Road Safety Audit – A29 Shripney Road

Stage:	1
Location:	A29 Shripney Road, Shripney, West Sussex
Site:	Proposed right turn lane and new site access (Audit of proposed modifications to informal pedestrian crossings)
ATSS Ref:	200108
Client Ref:	1845
Date:	5 February 2020

- 1.2 Further to discussions with Highway Officers, the scheme has been modified, and a further Stage 1 audit has been commissioned, to consider the changed proposals. These include:

PROJECT: SHRIPNEY ROAD, SHRIPNEY		
CLIENT: HANBURY		
PROJECT REFERENCE: 1845	DRAWING NUMBER: 07	SCALE: 1:1,000 @ A3
SHEET NUMBER: SHEET 1 OF 2

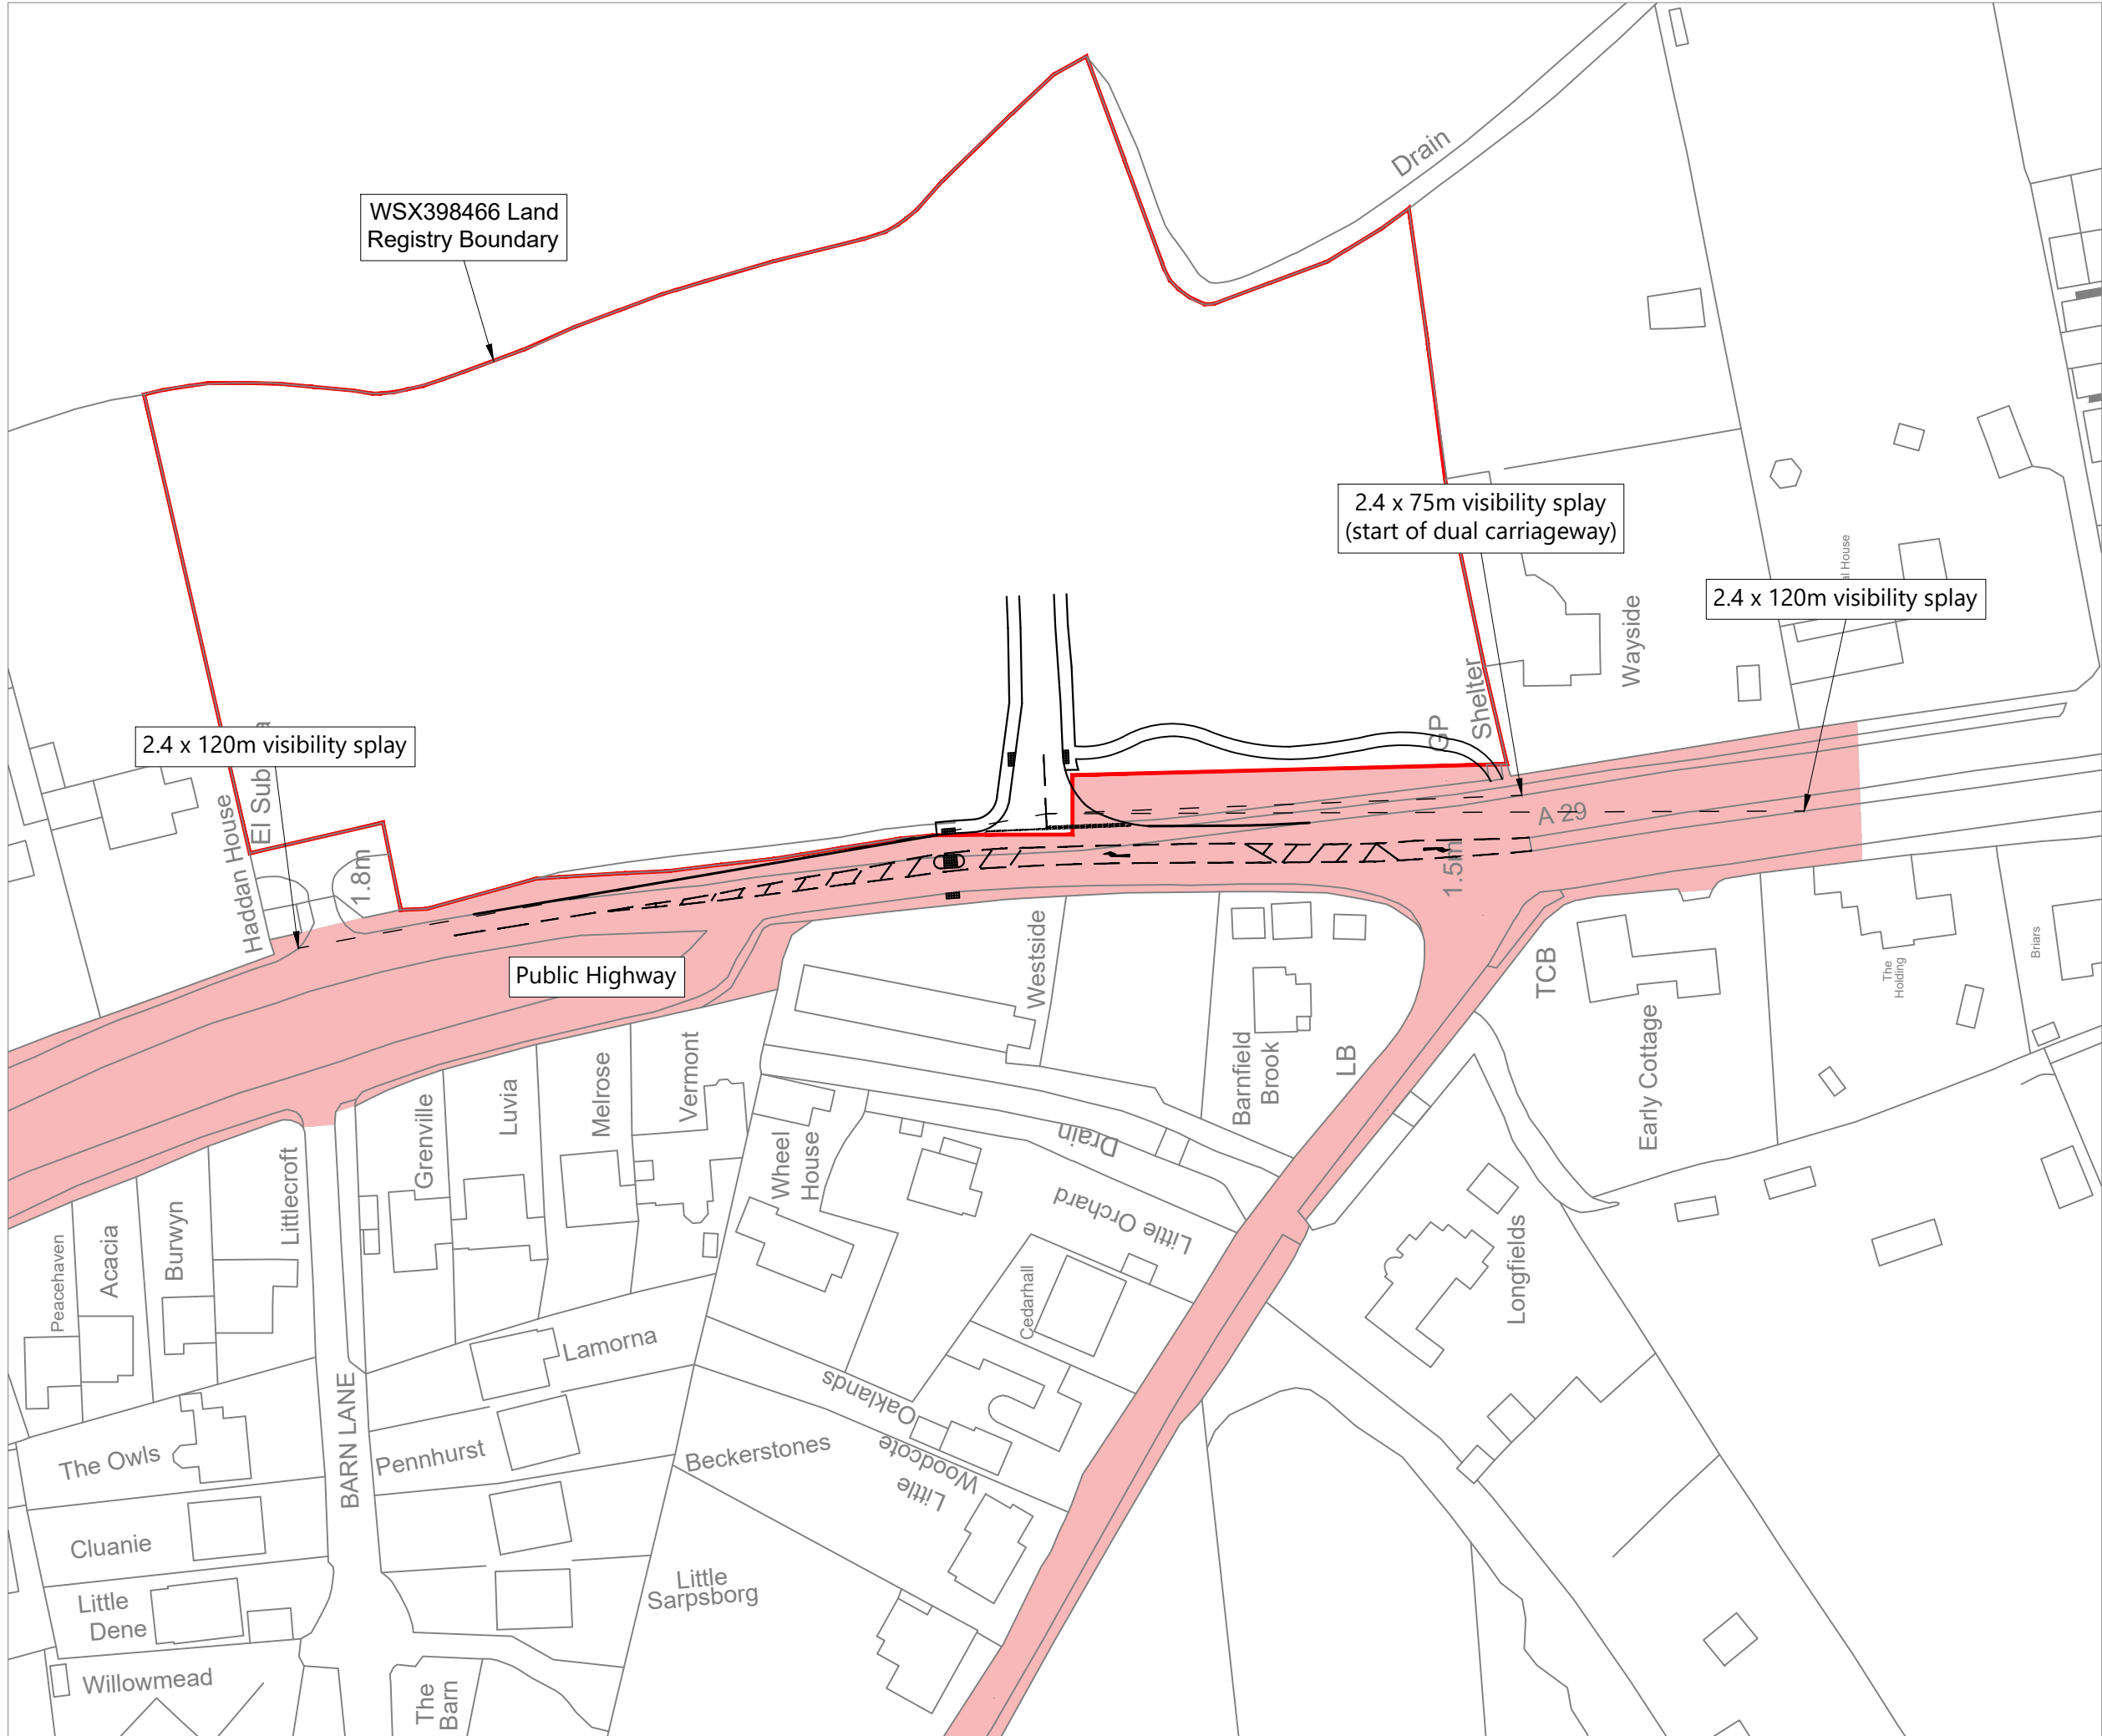
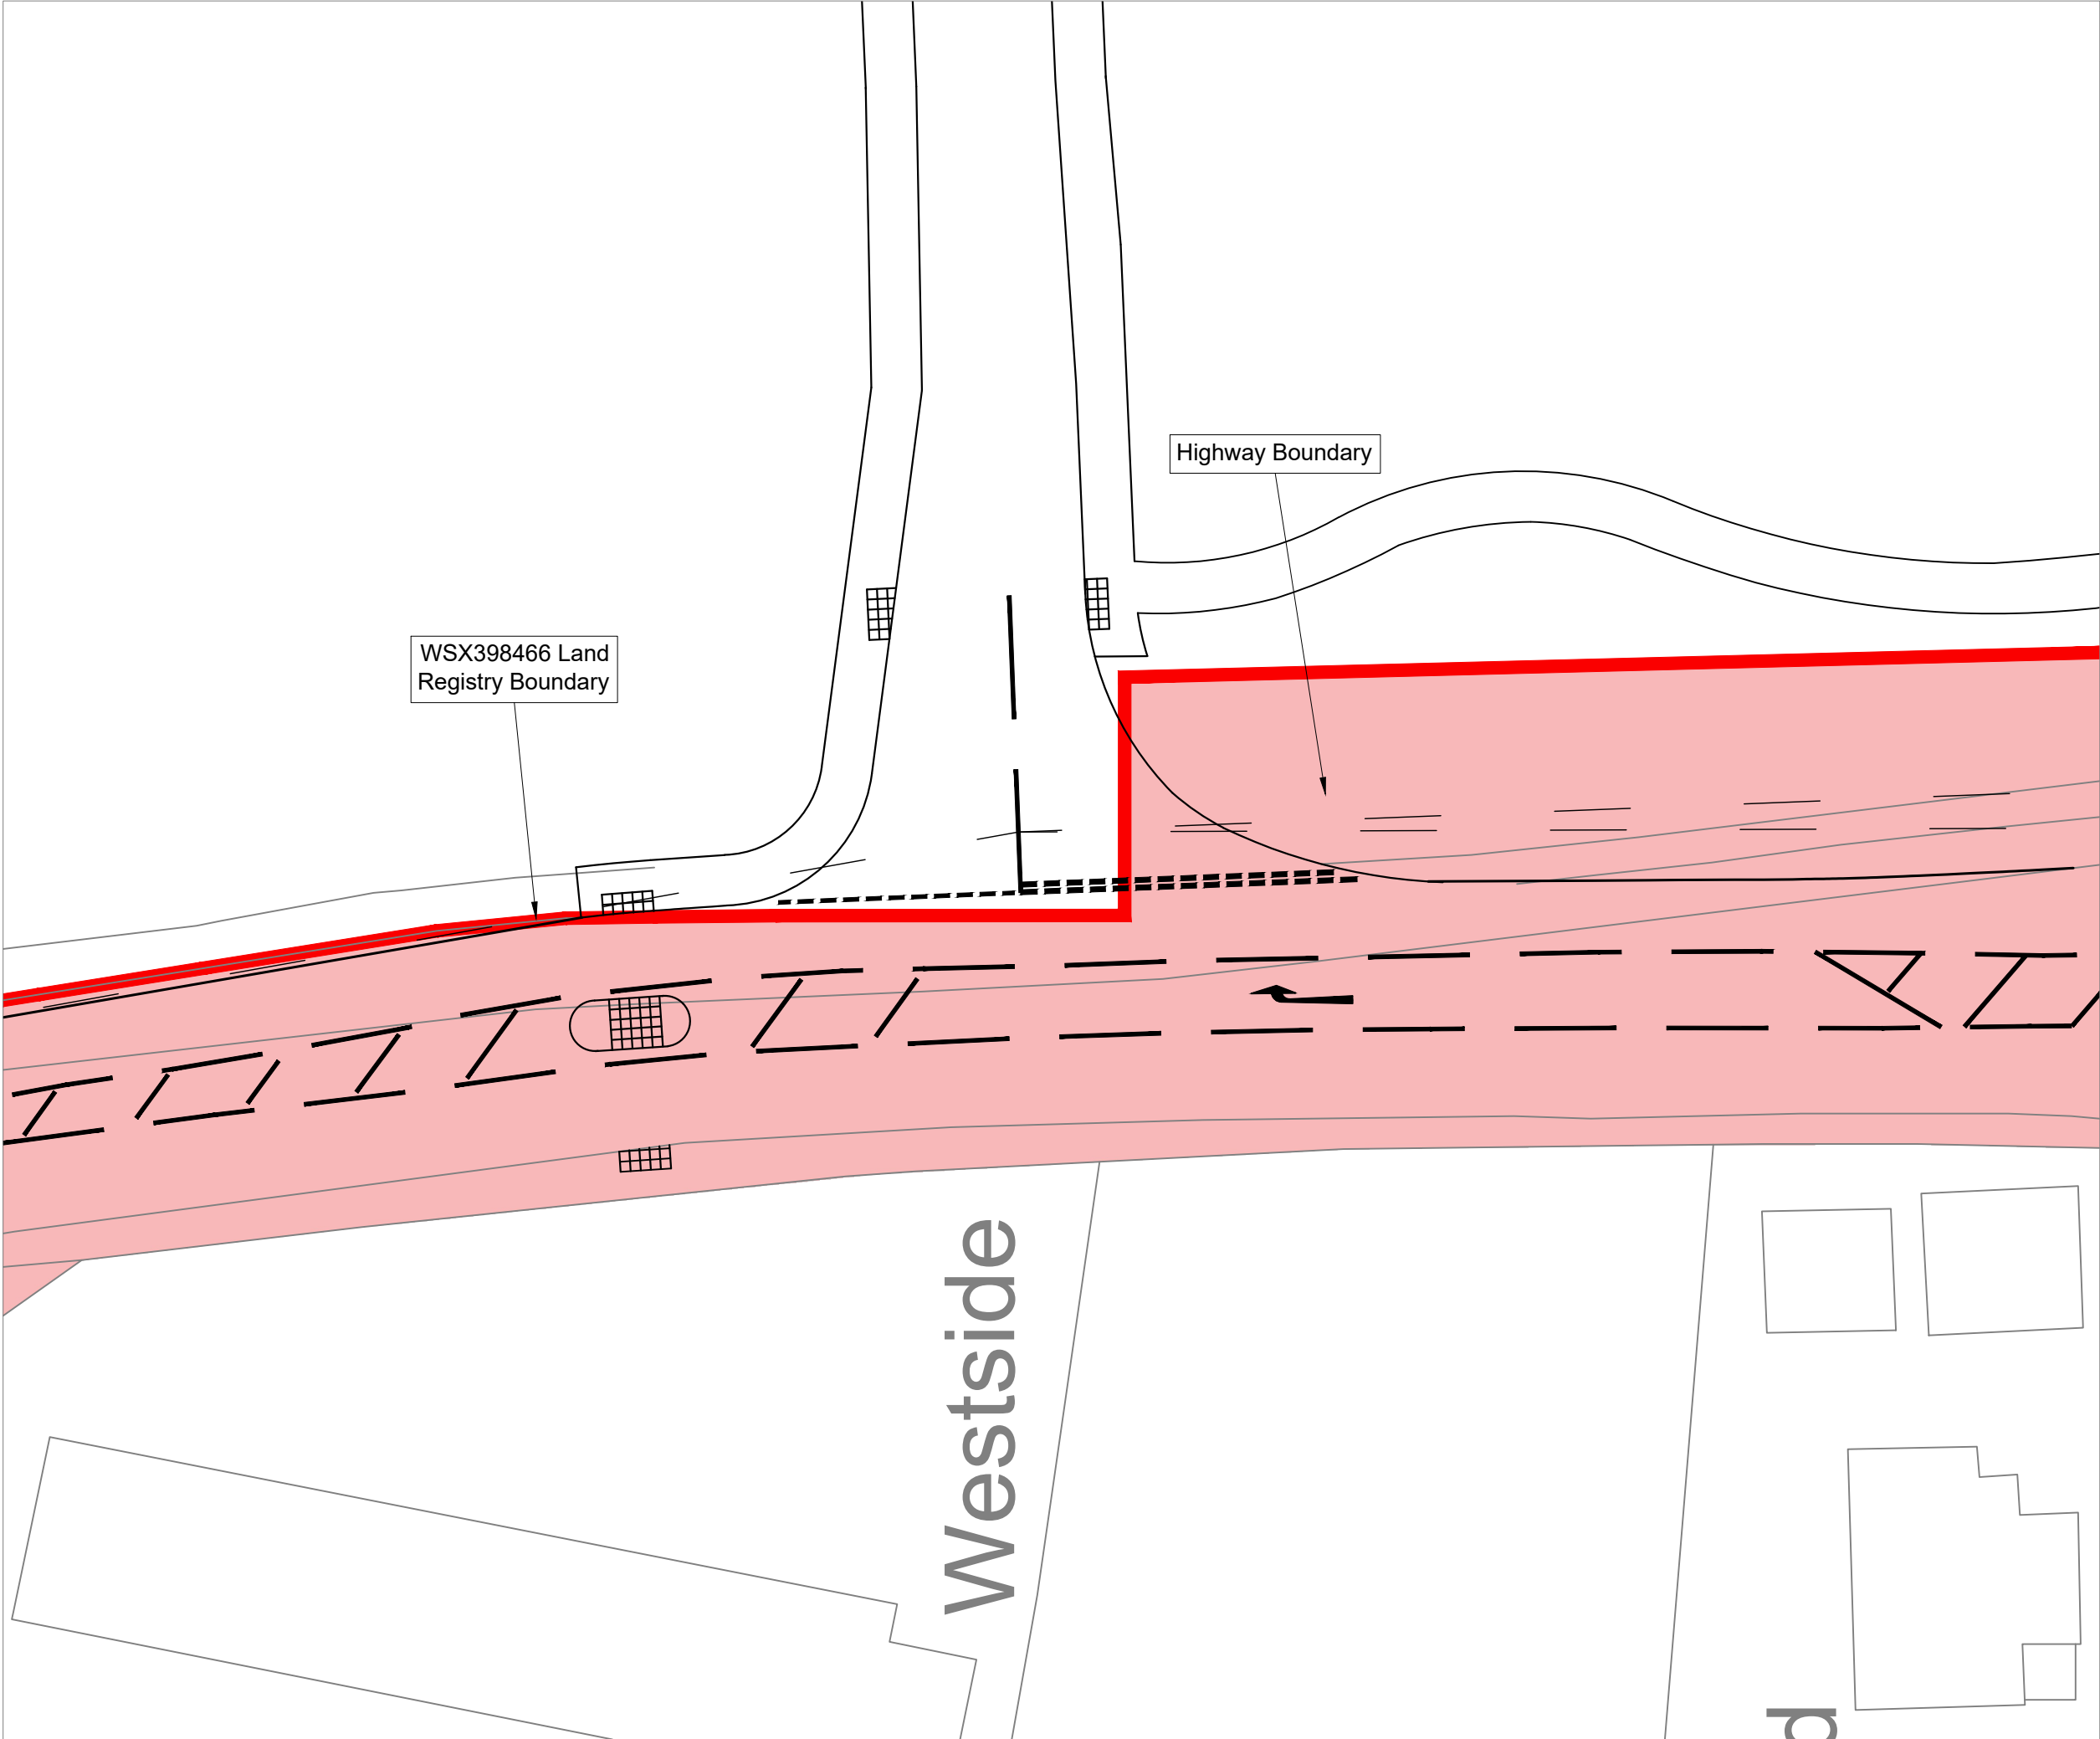
The existing informal pedestrian crossing at this location is proposed to be upgraded so that it is realigned and incorporates an area of tactile paving. The boundary wall and fence of an adjacent residential property inhibits visibility to the proposed crossing of those approaching from the south along the dual carriageway. This increases the likelihood of pedestrian/vehicle conflict particularly for vulnerable groups such as older users and those with mobility and visual impairment. The high approaching speeds observed on site together with the lack of any deflection for vehicles turning in to Shripney Lane will increase the risk of such collisions (see photo 2.1).

The existing boundary fence and wall inhibits visibility to the proposed pedestrian crossing point and increases the risk of vehicle/pedestrian conflict. Evidence on site also indicates that drivers turning left out of Shripney Lane mount the kerb as their attention is drawn to vehicles approaching from the south (often at speed), along the dual carriageway (see photo 2.2).

Recommendation – Realign and build out the existing kerblines at this corner to increase visibility to and from the crossing. The resulting increased deflection together with the reduced entry radius at this corner will influence entry vehicle speeds and minimise the risk of conflict with those crossing.

Recommendation – Increase visibility at this point by building the kerb further out into the carriageway. If the existing kerblines were realigned on both sides of the junction and the refuge island was omitted visibility would be improved on both sides of this junction (see problem 2.1).
